16, NABBS LANE
SWITHWAITE
NR, HUDDERSFIELD
HD7-5AU

10-06-2024
APPLICATION NUMBER
2024/91501

ERECTION OF FRONT PORCH WITHIN A
CONSERVATION AREA. EAST VIEW

COMMENTS. From 14, NABBS LANE

4 PROPOSED FRONT ELEVATION  
1:50@A1

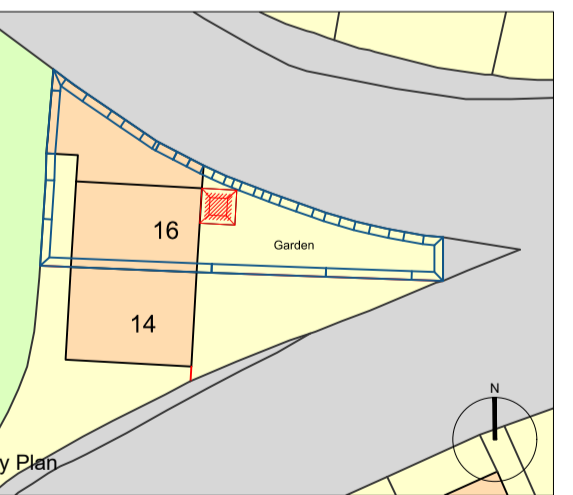
THE HOUSE, COTTAGE IS IN FRONT VIEW
HAS YOU WALK UP NABBS LANE IT
LOOKS A PROPER EYESORE IT'S CHANGED
THE CHARACTER LOOK OF BOTH THESE
SEMI DETACHED COTTAGES 84 & 16 BEING
A BESPOKE DESIGN DOESN'T MATCH THE
OLD BUILDING SHAPE OF THE HOUSE, TOO HIGH.
